CITY OF ALBUQUERQUE

February 10, 2020

Re: Barlow Shop
6205 Wilshire Ave NE
Traffic Circulation Layout
Engineer's/Architect's Stamp 12-11-19 (C18D070)

Site Plan

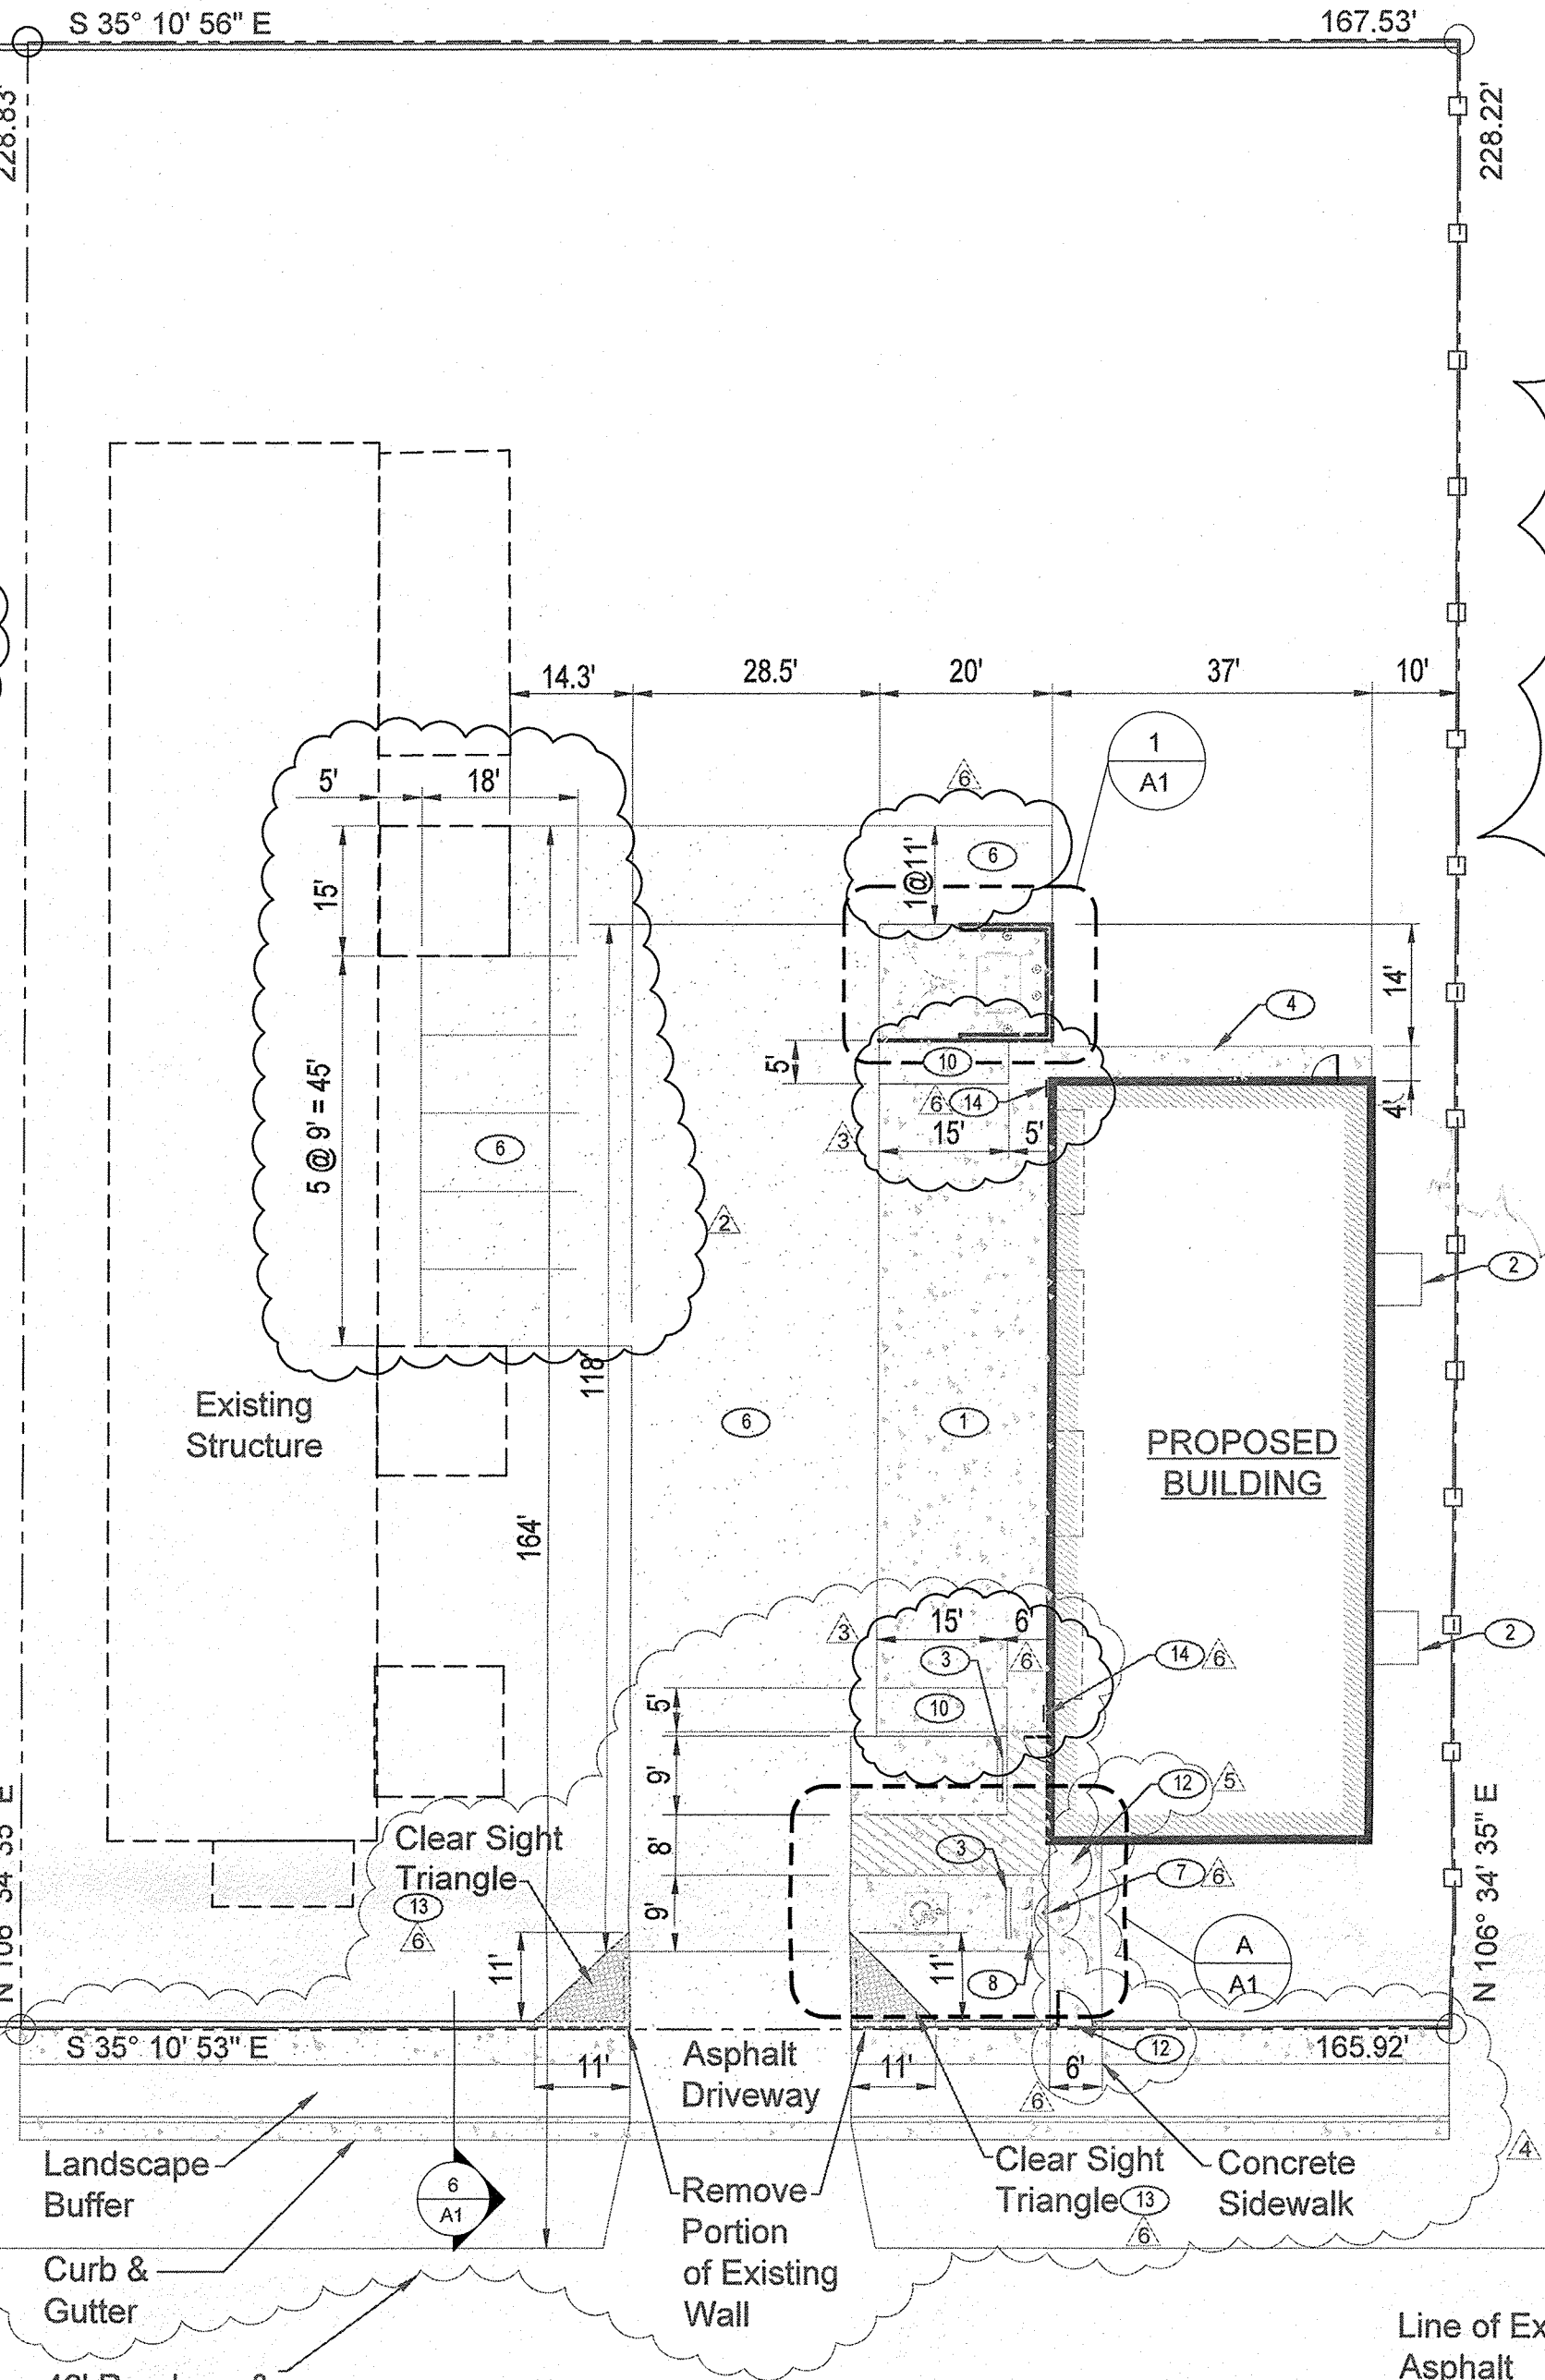
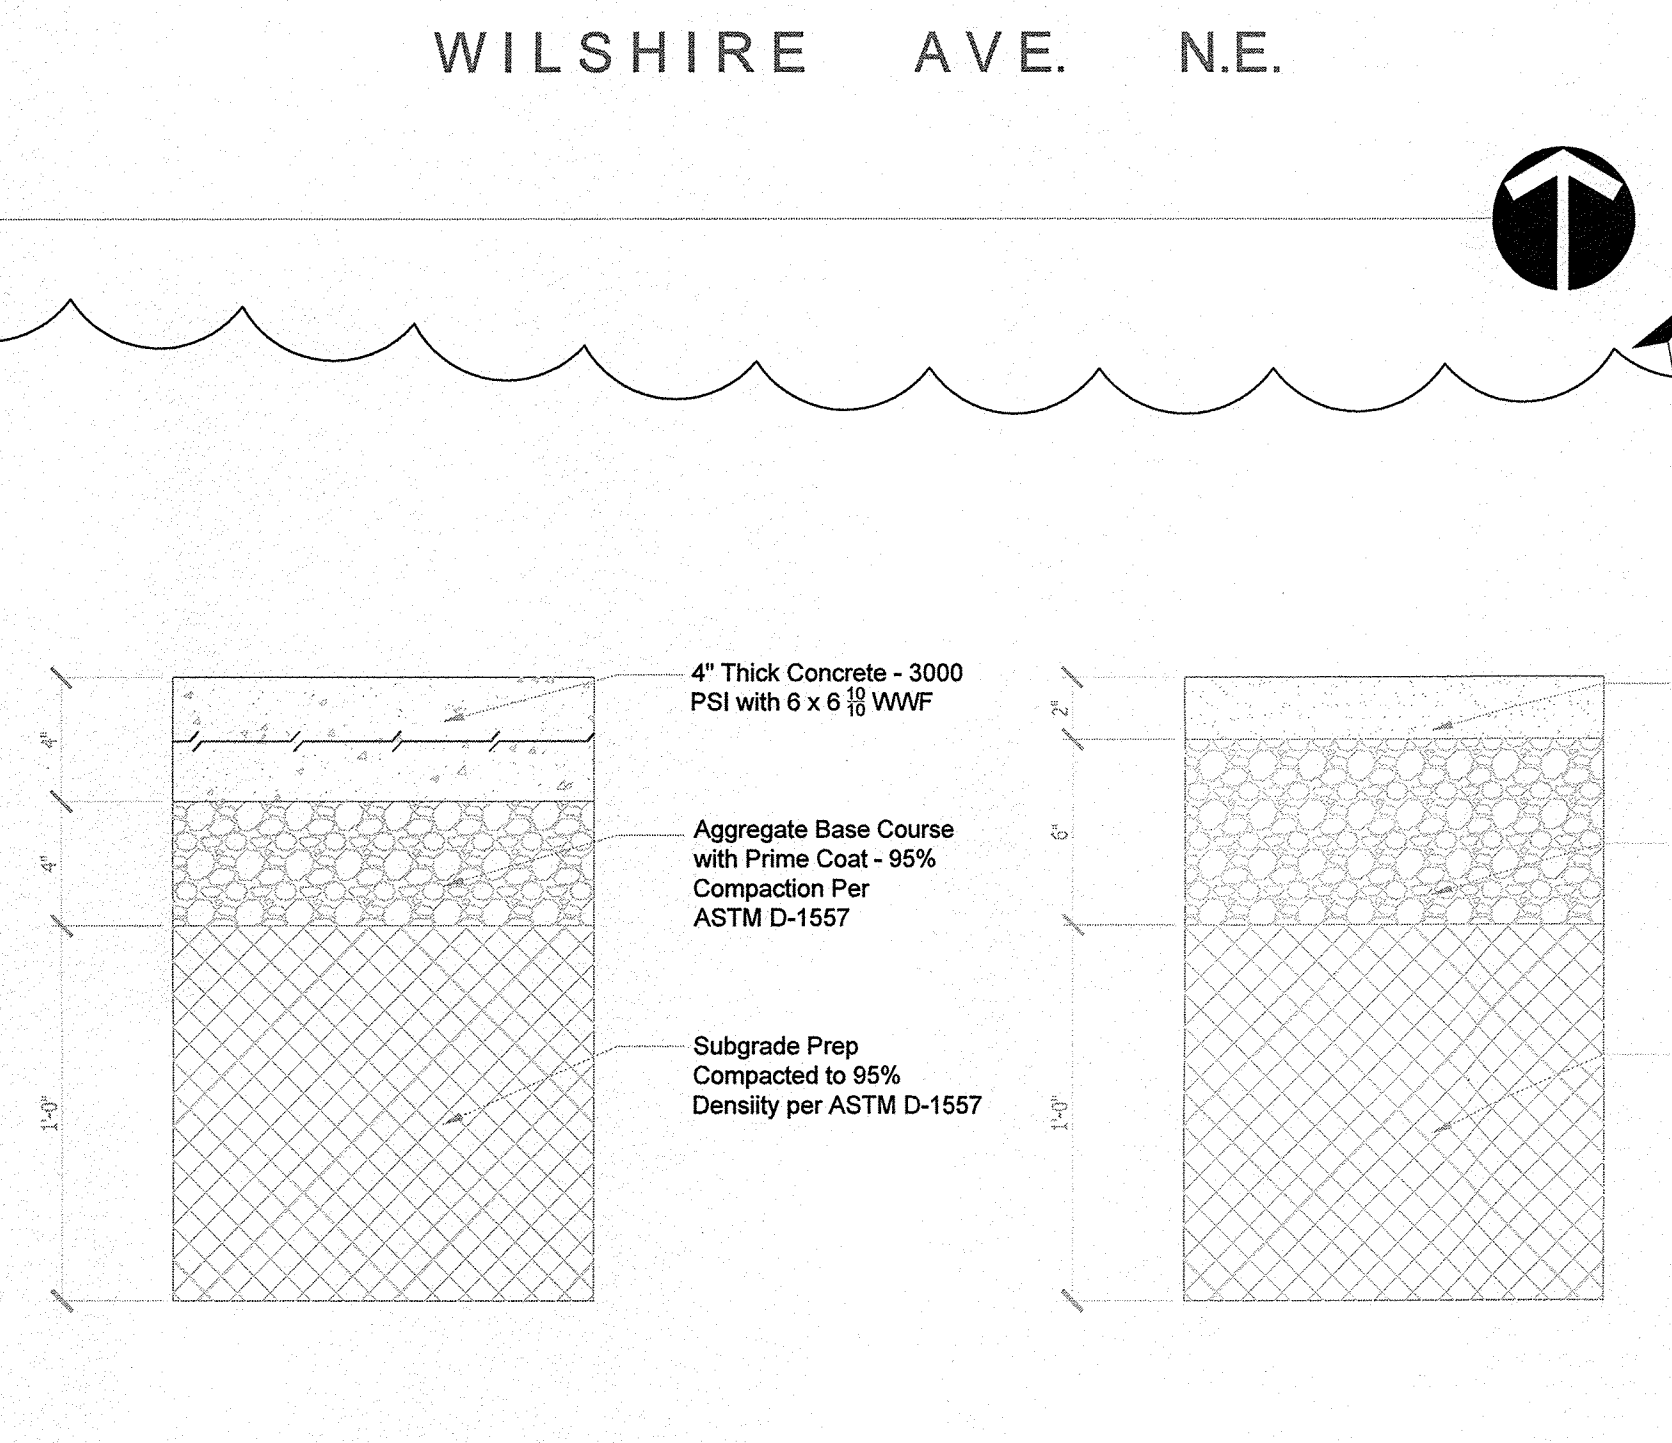
Solid Waste	Carla Wilkins cwilkins@cabq.gov	christinachavez@cabq.gov	AuthorizedWithConditions	CO Required. Approved. Carla Wilkins 1-8-20. Refuse service will need to be a roll-out dumpster only, due to the angle of the new/proposed refuse enclosure indicated on both the Revised Site Plan (Pg. A1 for 1-7-20) and the TCL Site Plan. All Pre-Pour Inspections must be done by Solid Waste Department.
